Application by Tritax Symmetry (Hinckley) Limited for an Order Granting Development Consent for the Hinckley National Rail Freight Interchange – Deadline 6 submission

Hinckley National Rail Freight Interchange

Leicestershire County Council Design Review Comments as presented to the Applicant team on 14.02.2024 and as discussed at a meeting with the Applicant team on 15.02.2024

Project - Originator - Zone - Level - Type - Role - Number	Status	Rev
HRF-BWB-HGN-HW04-DR-CH-0100	S2	P01

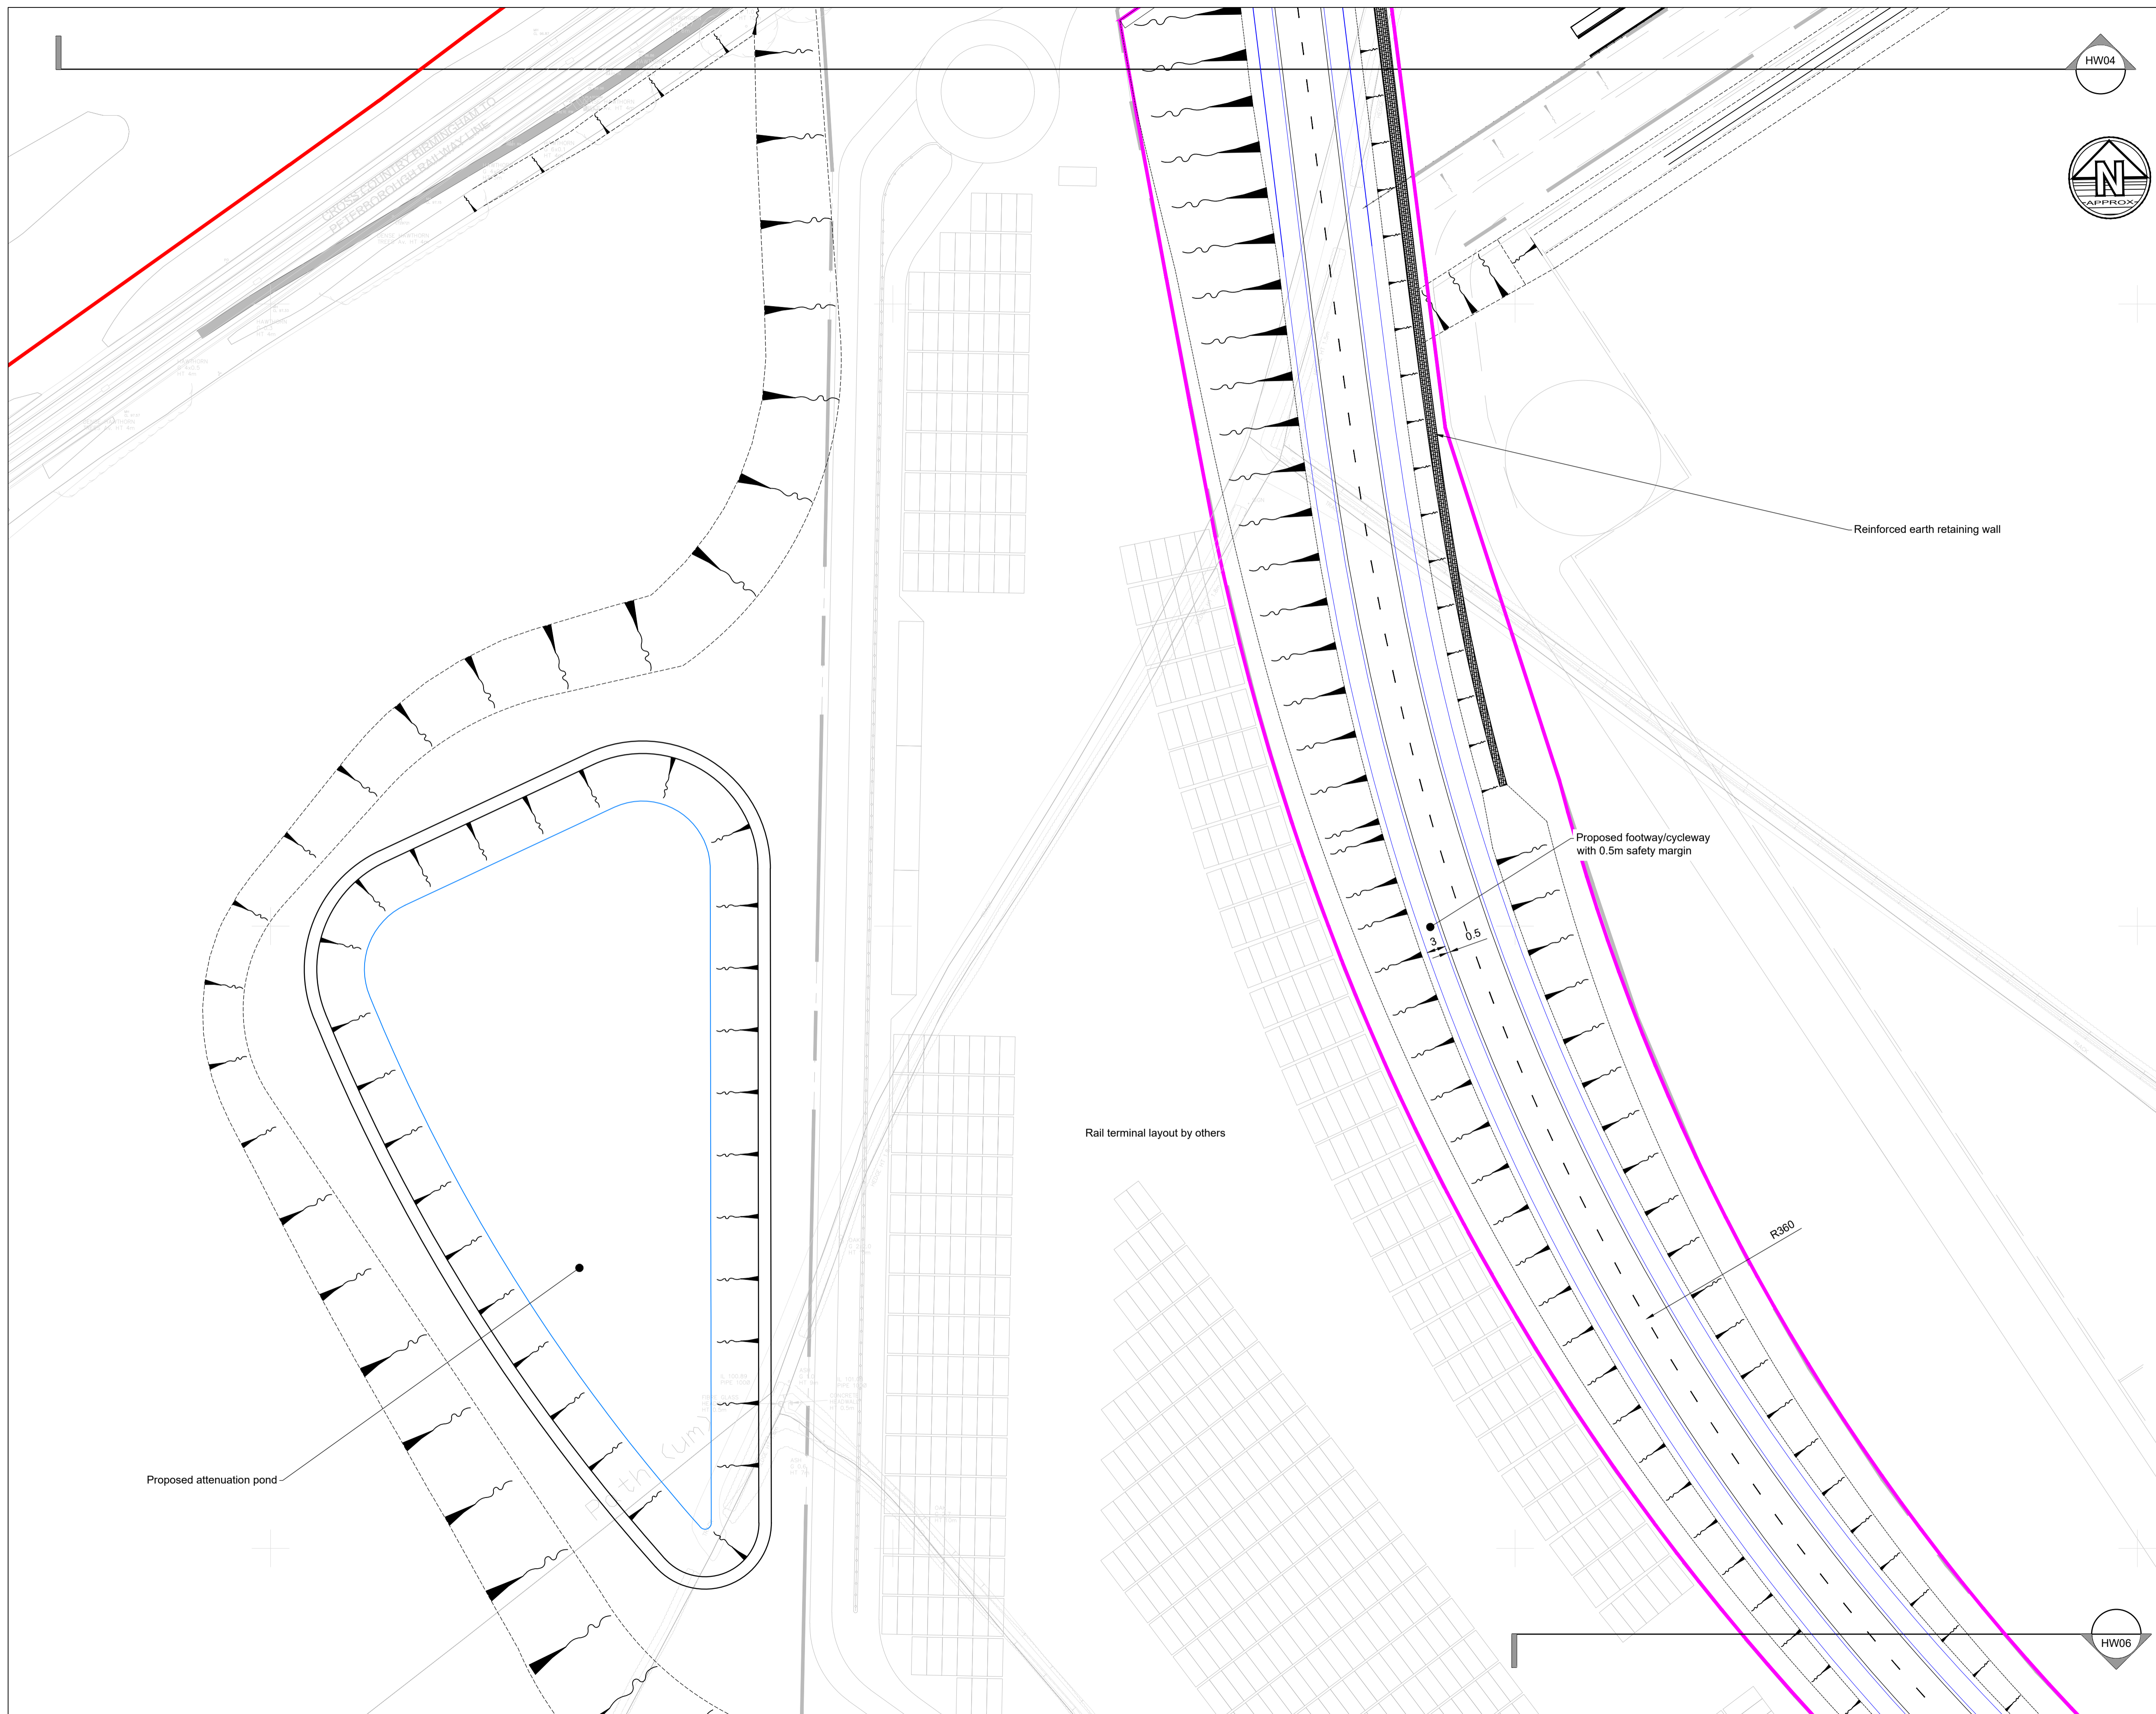
- 2.4.1 Rail bridge, underpass and retaining wall – comments from LCC Structures team required.
- 2.4.2 RRRAP Assessment also required taking into account proposed structure. The designer will need to give consideration to VRS requirements, which will potentially affect visibility splays.
- 2.4.3 Visibility to/from proposed pedestrian crossing on inside of bend needs to be shown. Also concern regarding visibility restriction in the vertical plane due to the crest curve over the rail bridge just to the South of this crossing provision.
- 2.4.4 Concern that 40mph speed restriction would not be sufficient to control speeds for 70kph design speed.
- 2.4.5 Should the connection between the bridleway and the cycle facility be more than just a simple dropped crossing as shown here?

Project - Originator - Zone - Level - Type - Role - Number	Status	Rev
HRF-BWB-HGN-HW05-DR-CH-0100	S2	P02

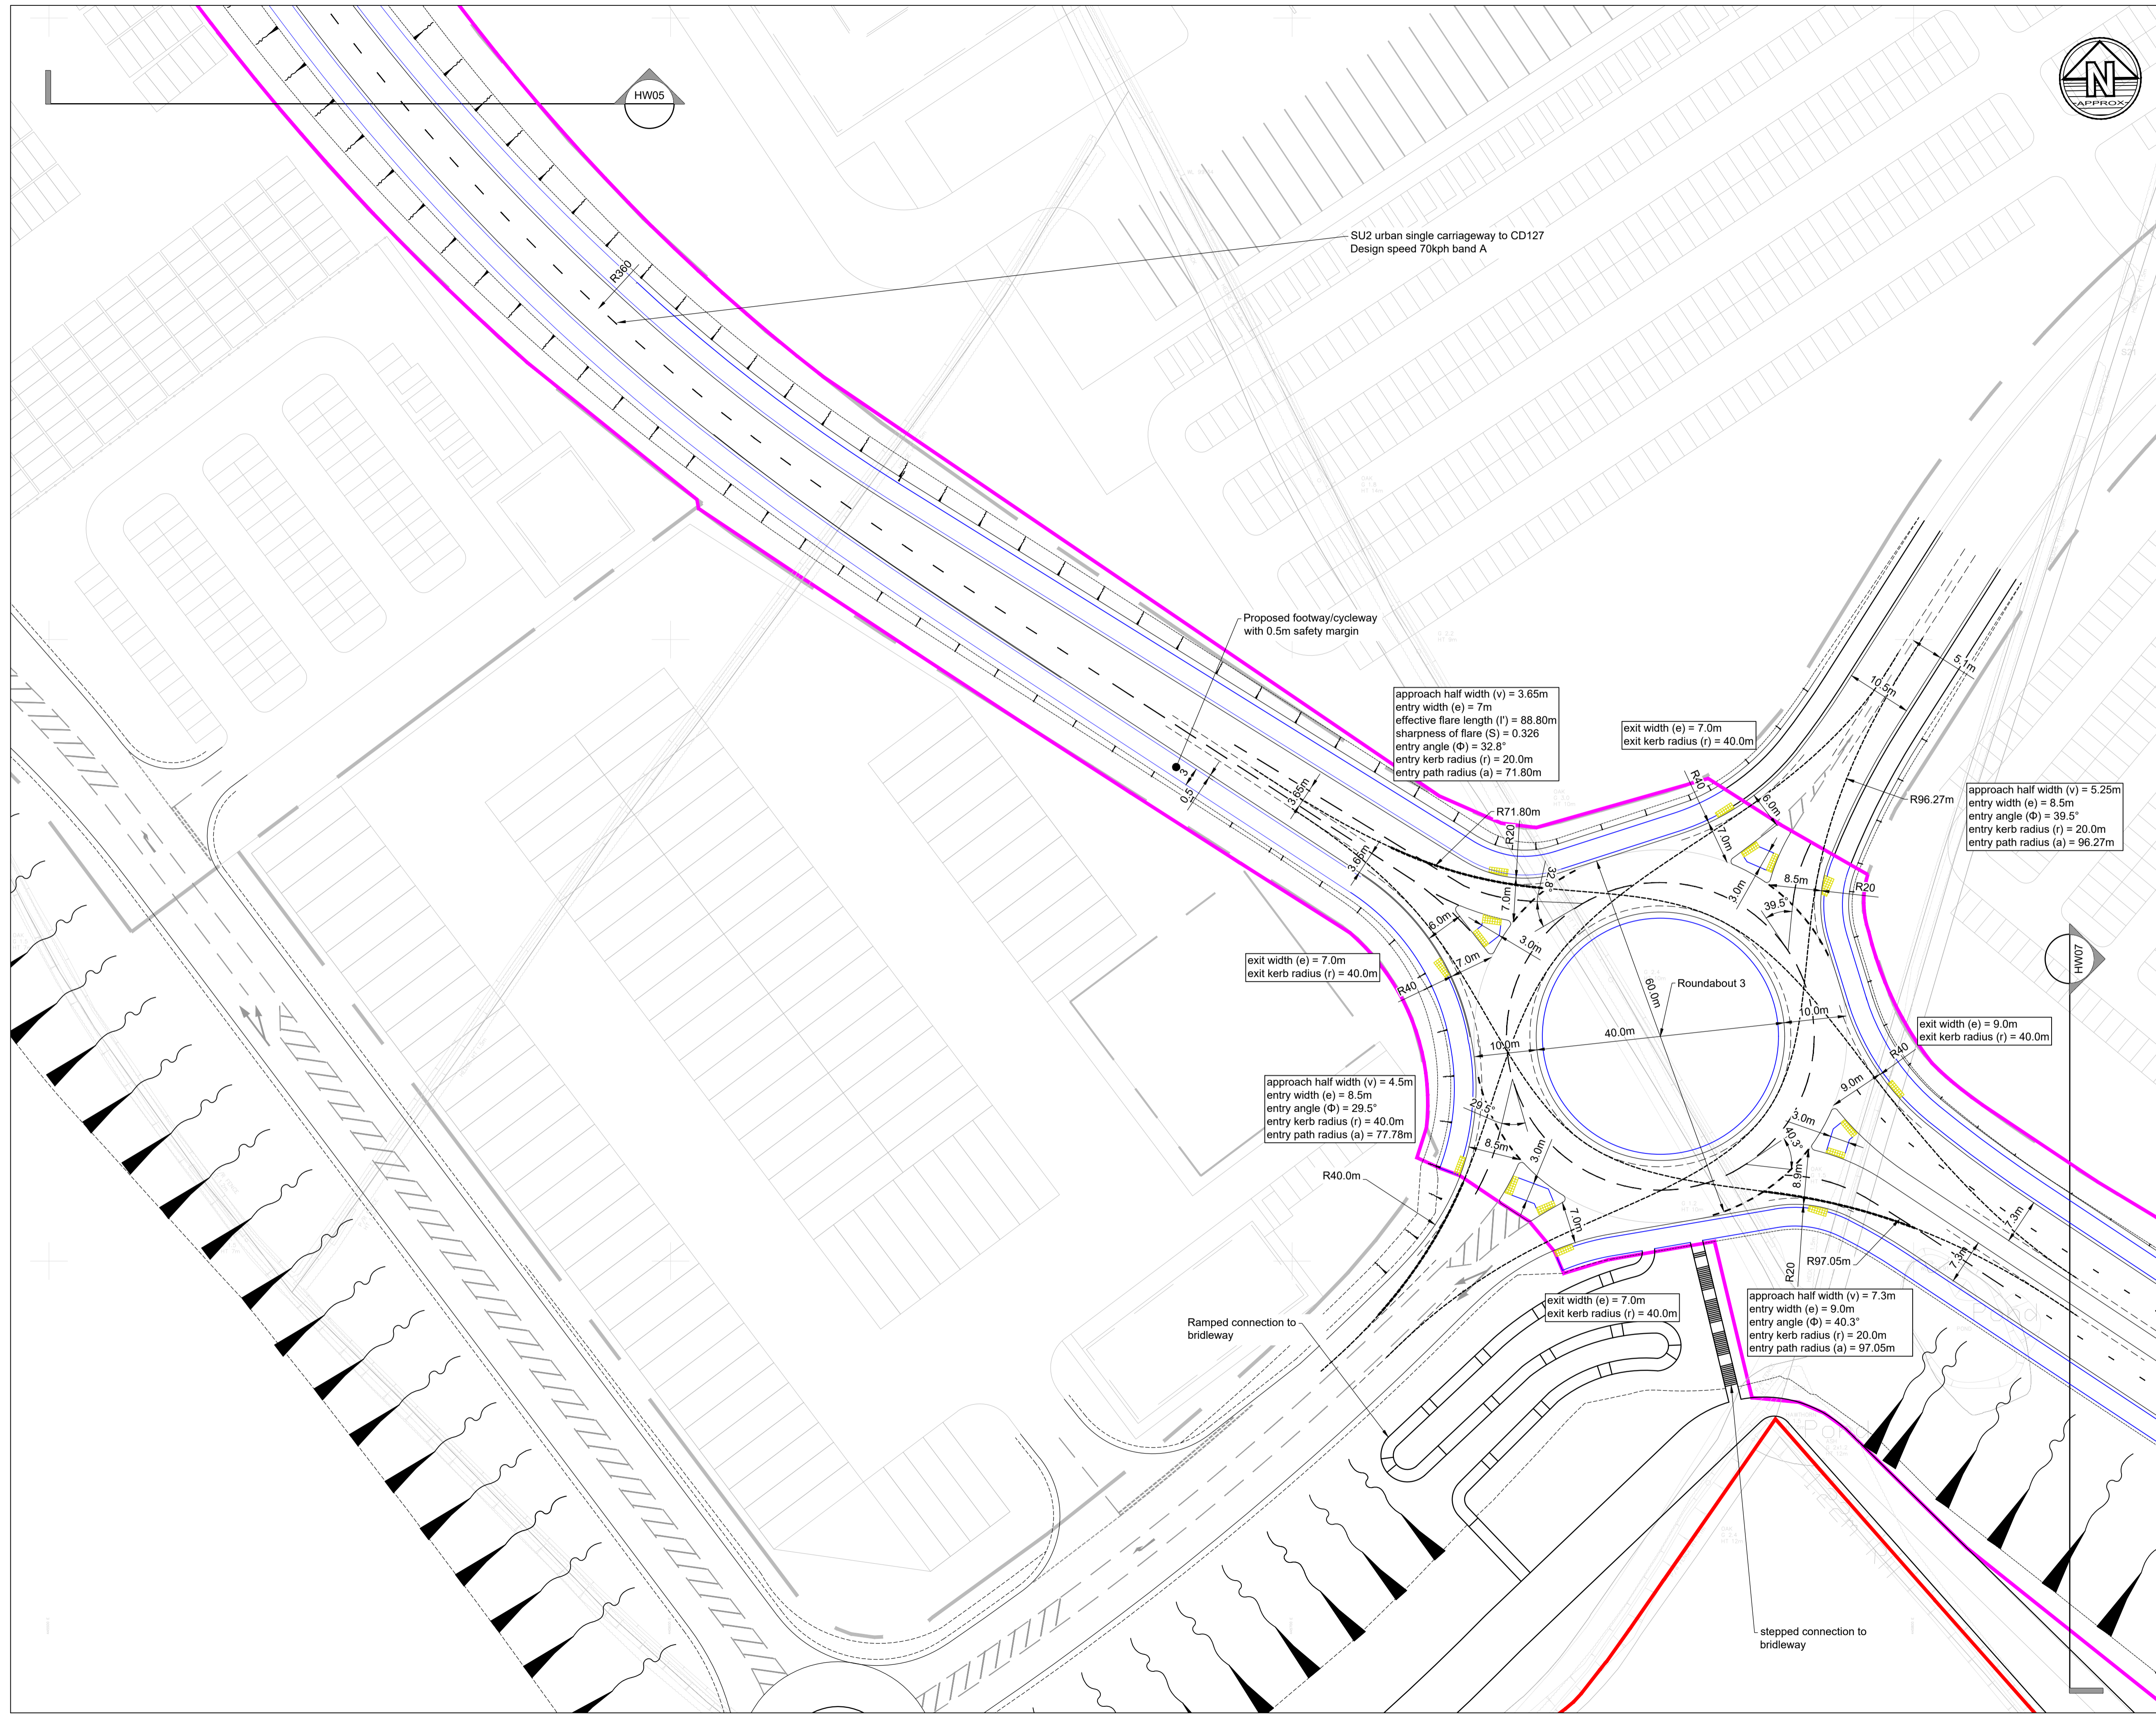
- 2.5.1 Retaining wall – comments from LCC Structures team required.
- 2.5.2 RRRAP Assessment also required taking into account proposed retaining wall and earthworks embankment.
- 2.5.3 Concern that 40mph speed restriction would not be sufficient to control speeds for 70kph design speed.
- 2.5.4 Bridge will not be considered for adoption by LCC.
